CLEAR VIEW INDUSTRIAL PARK, FILING 2A

GRADING, STORM AND EROSION CONTROL PLANS

PCD Filing No.:
CDR208

STORM LINE FOR POND

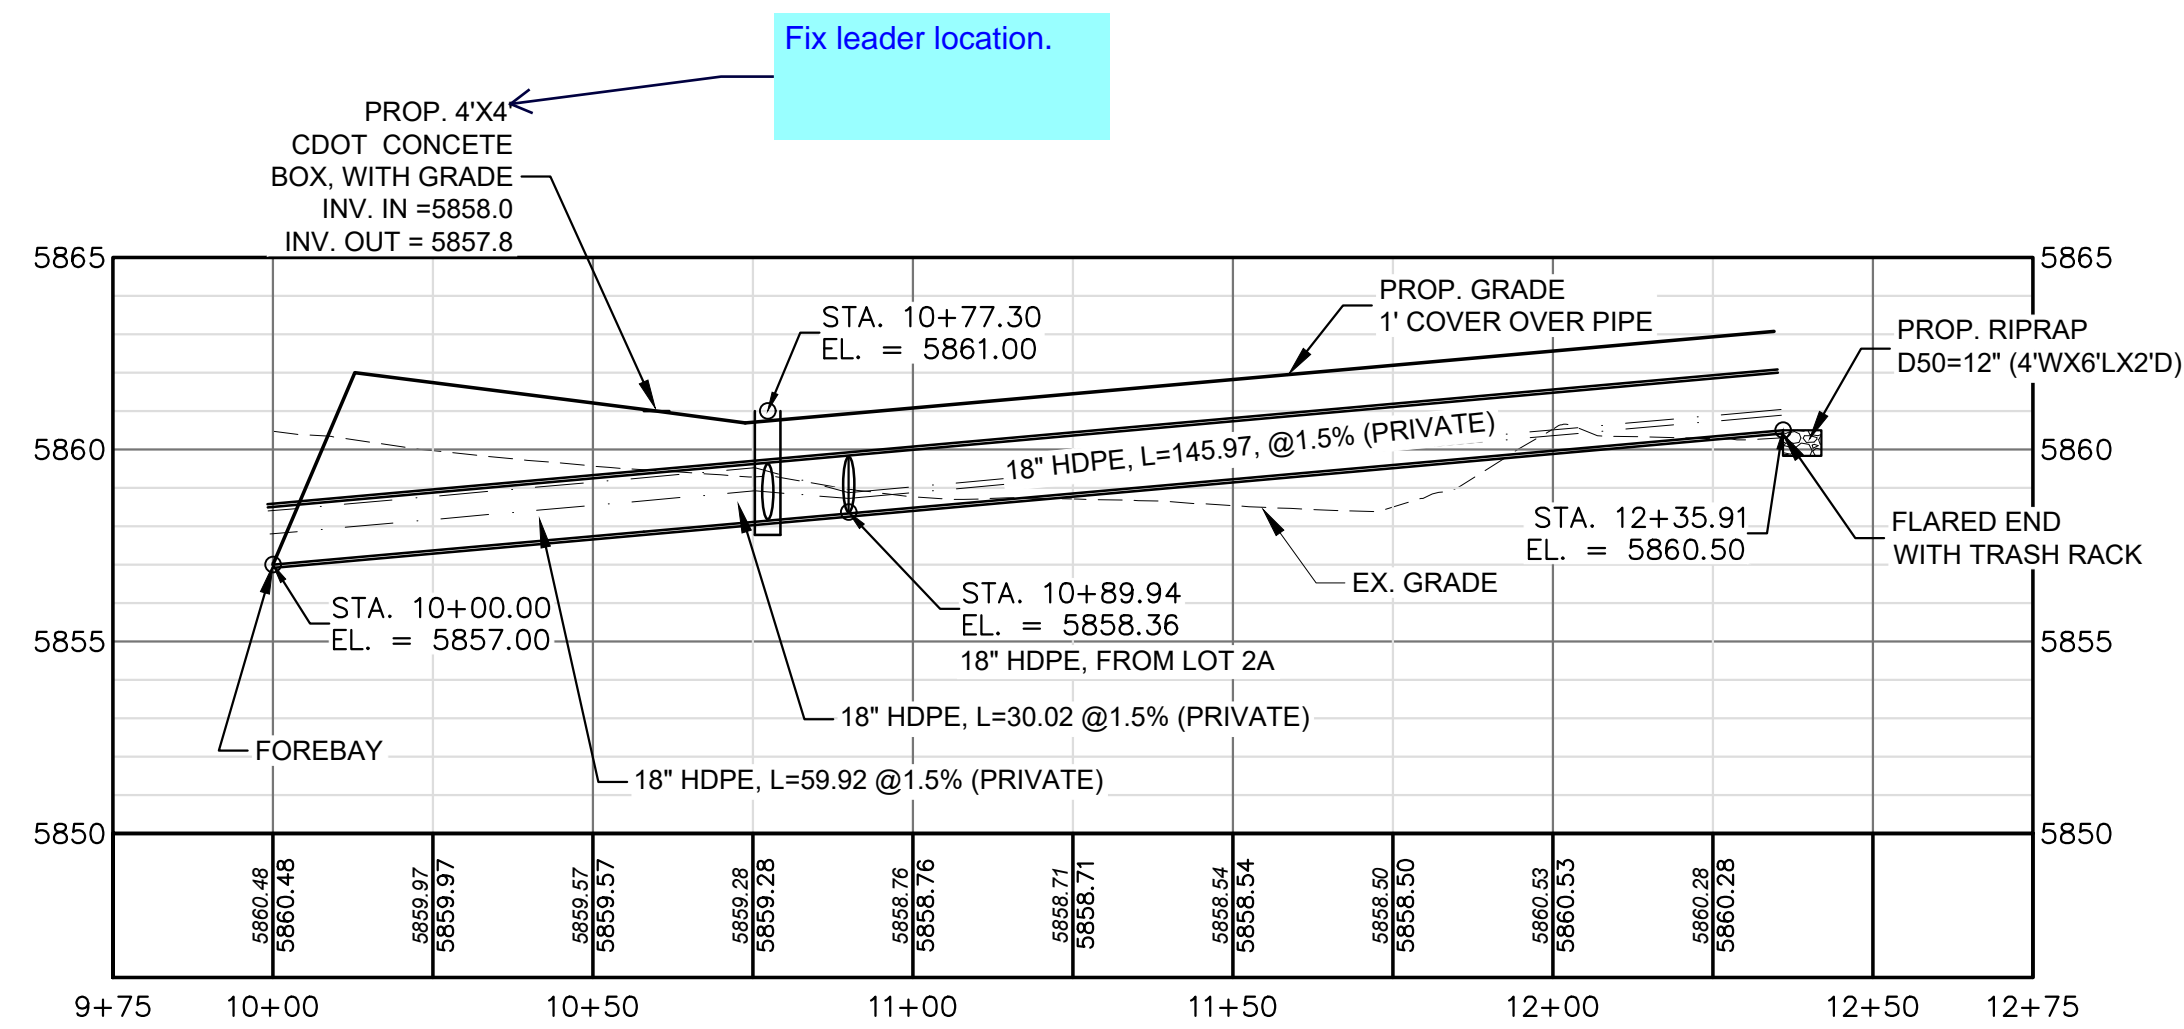
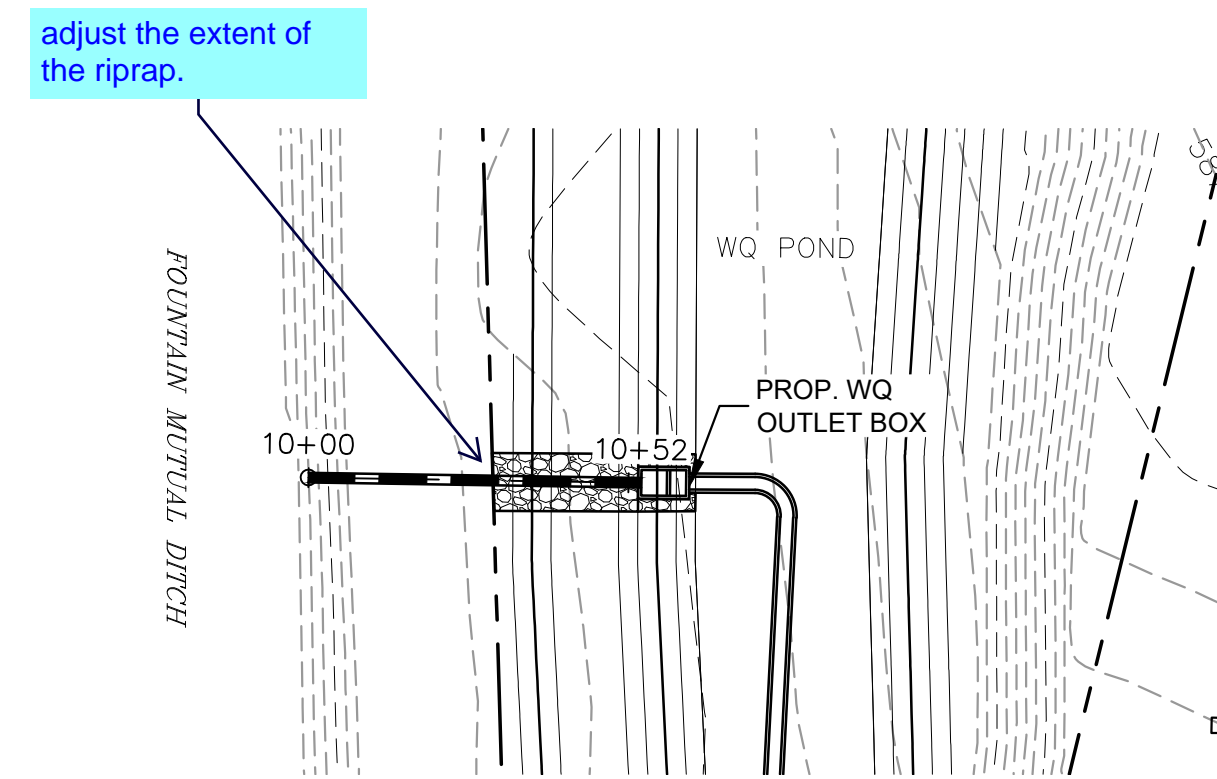
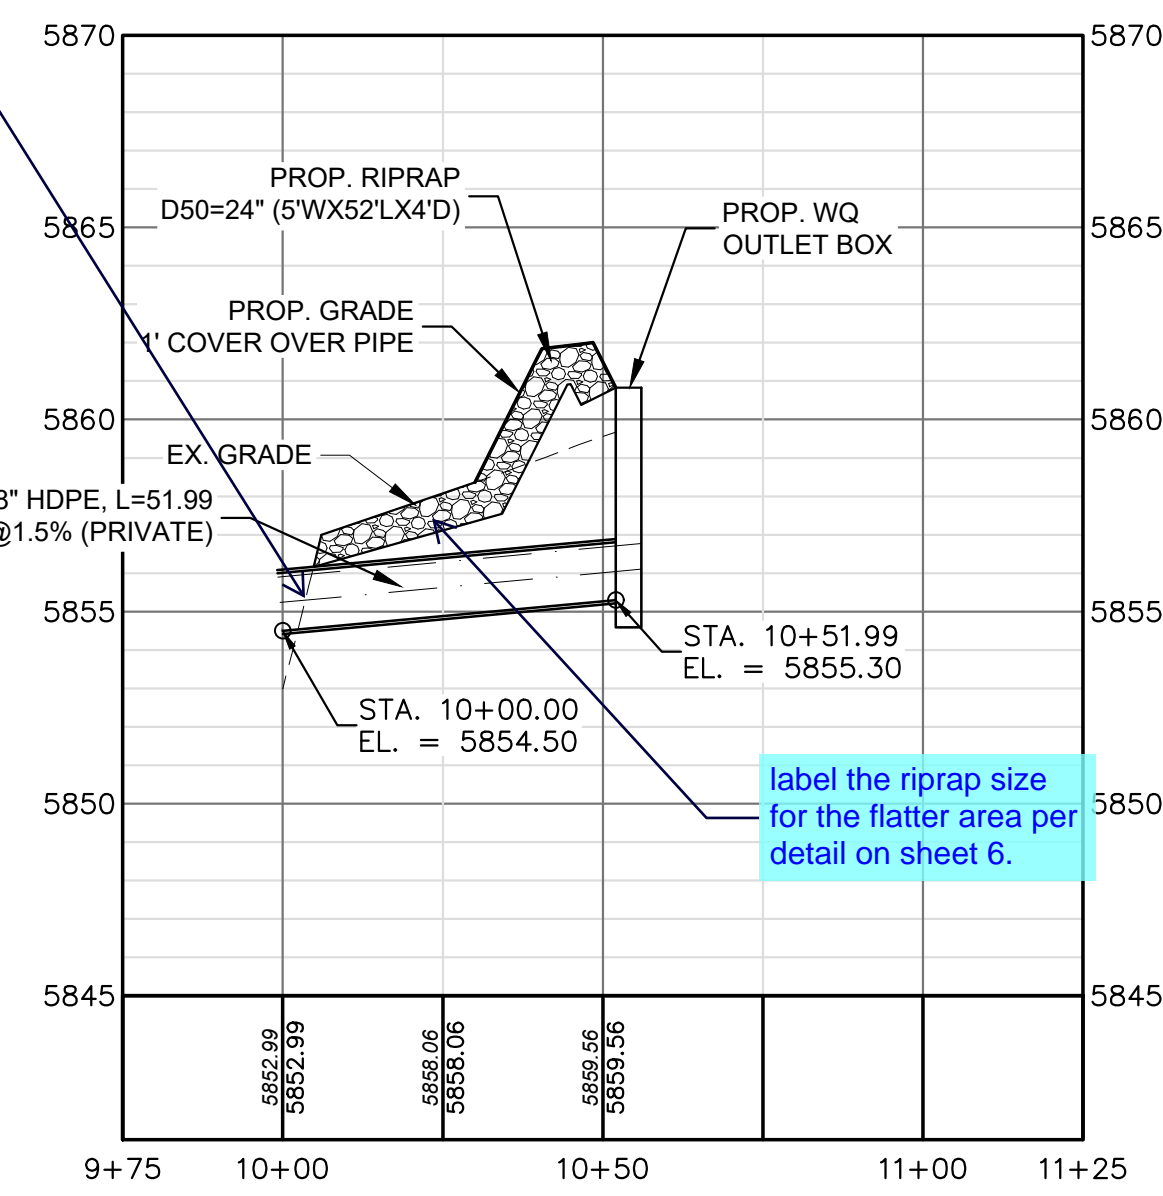
It appears that STA
10+77.30 is Lot 3A inlet.
Clarify which detail will
be used at this location.

At pond outlet pipe? No riprap shown at this location on the plan. Clarify note and revise plan as needed.

SHEET TITLE:
STORM PLAN
AND PROFILE

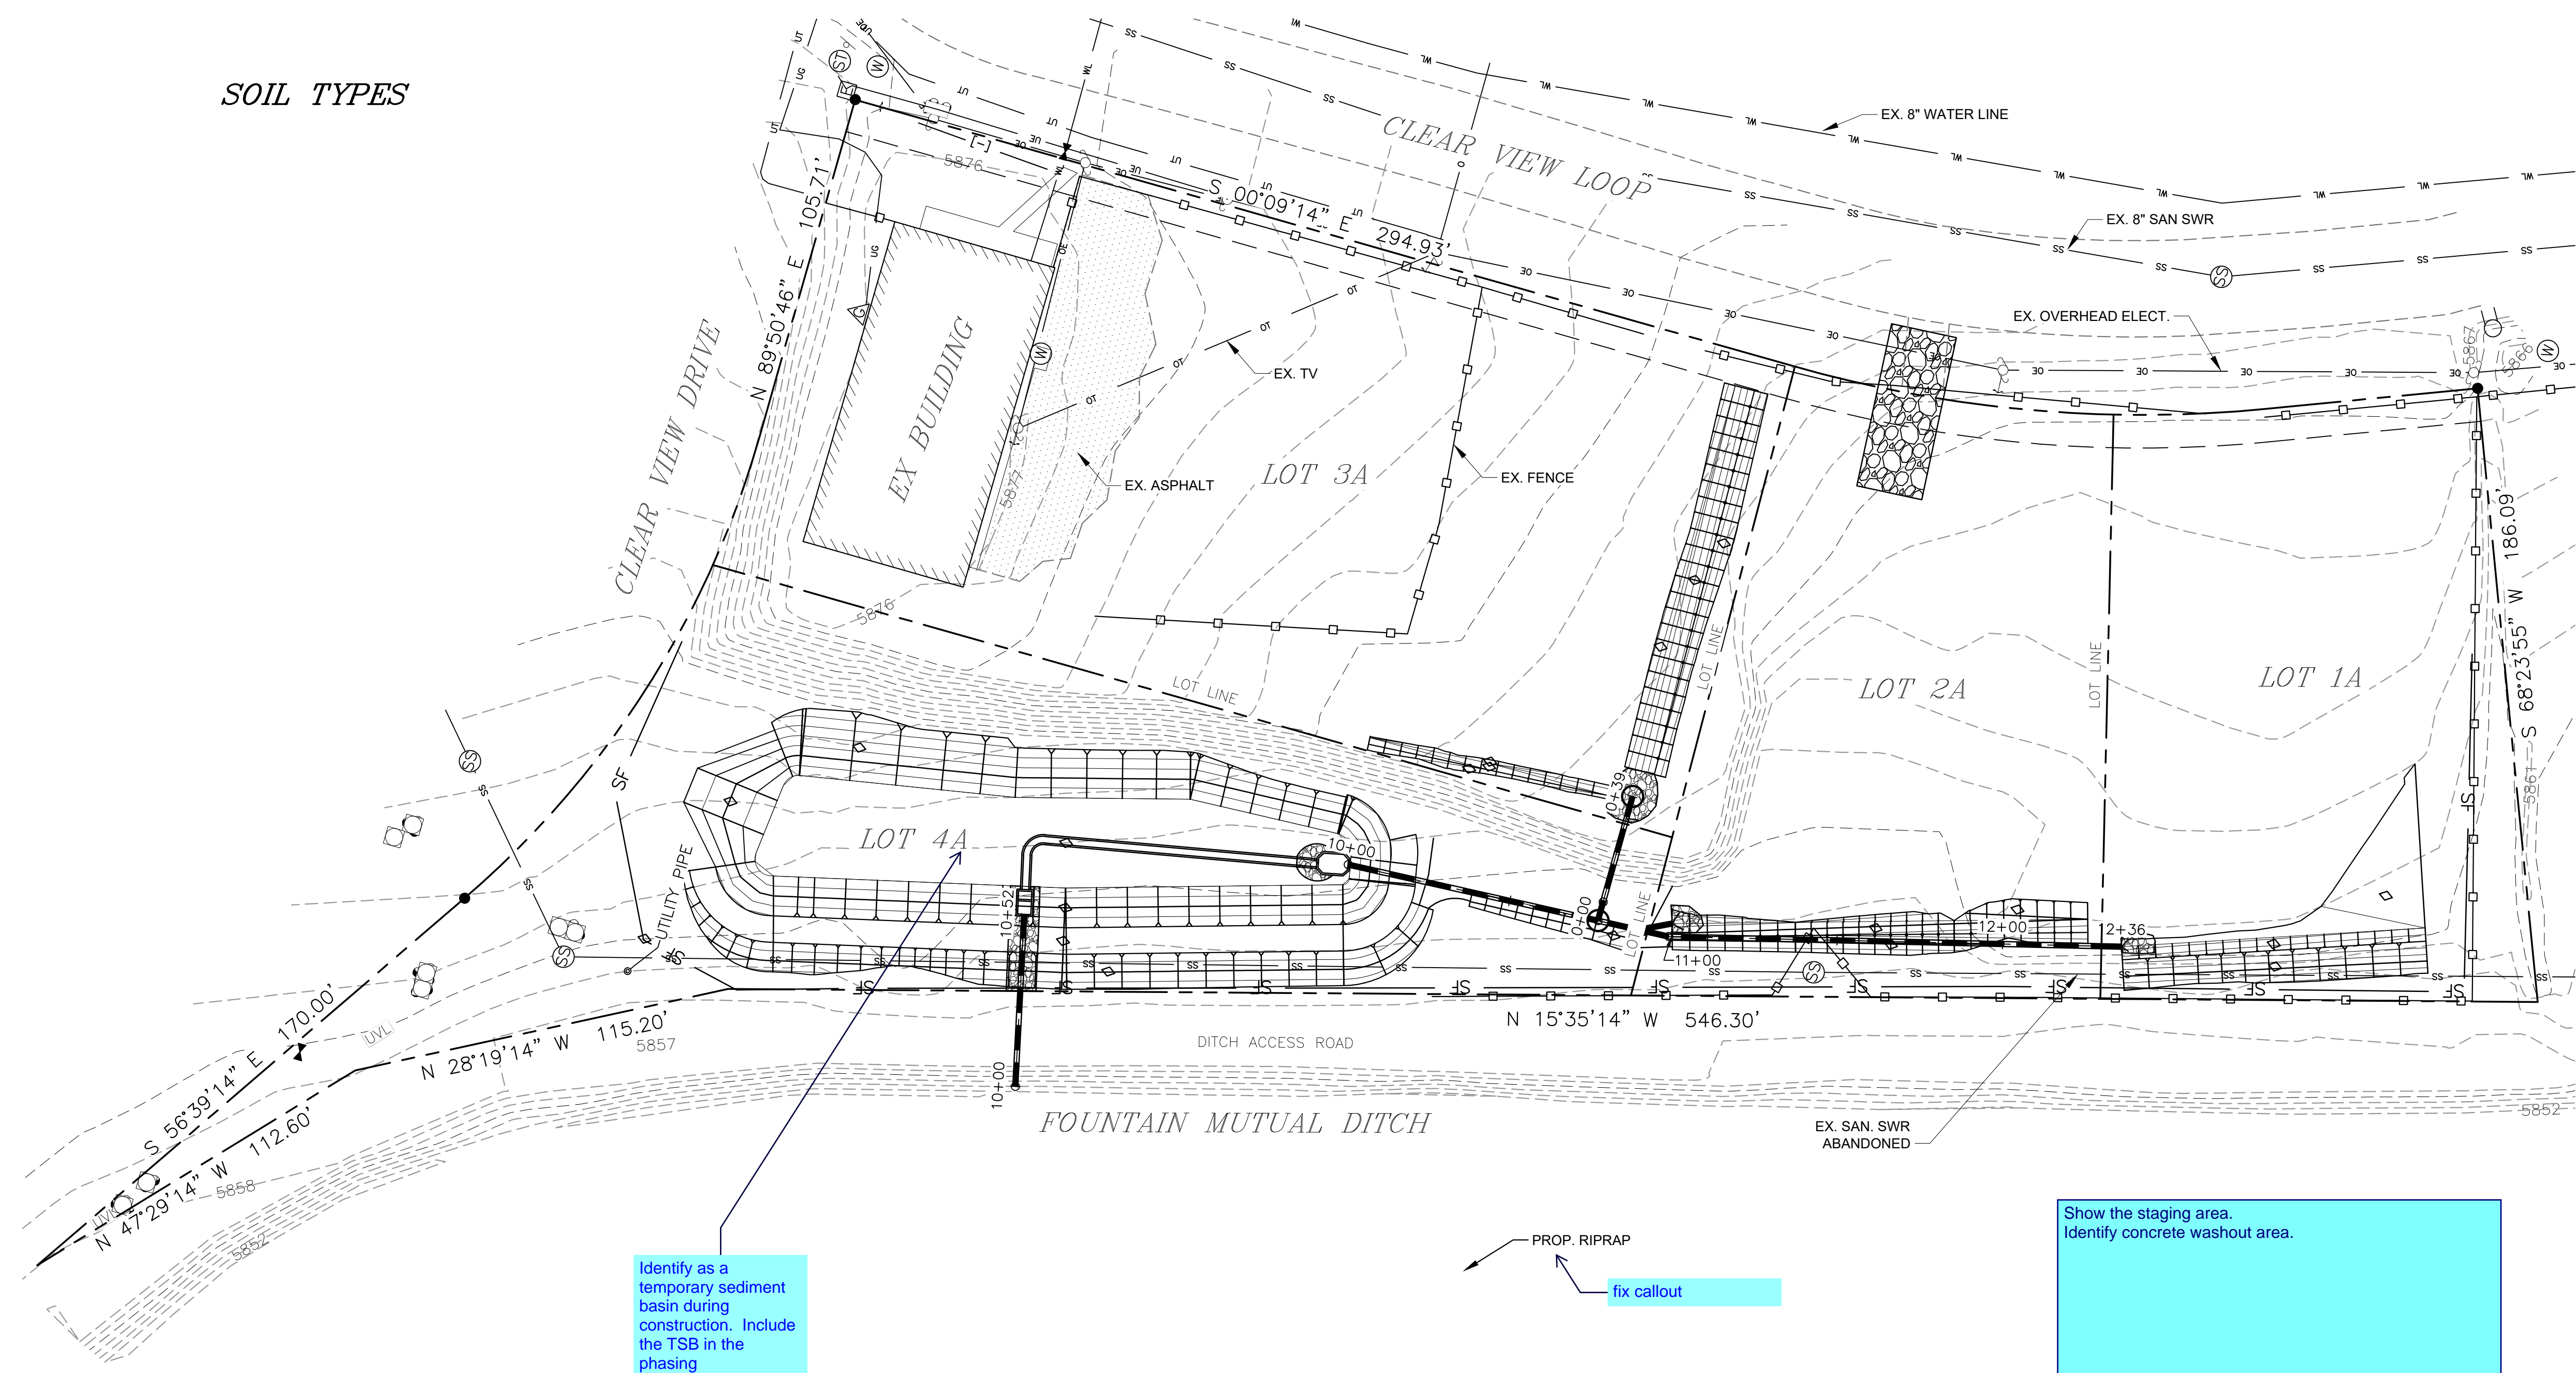
If any vehicles will be accessing the site through the Clear View Dr entrance during construction, VTCs must be shown

Provide detail for the outlet. There needs to be some kind of erosion control or outlet protection BMPs here. Is the outfall located offsite? Limits of disturbance will need to include this area.

add inlet protection

This note does not appear to function as intended because the silt fence only covers 2 sides of the site. Construction perimeter should be shown on a separate linetype so all sides of the construction limits can be outlined

Where will these be installed? Don't see any on plan
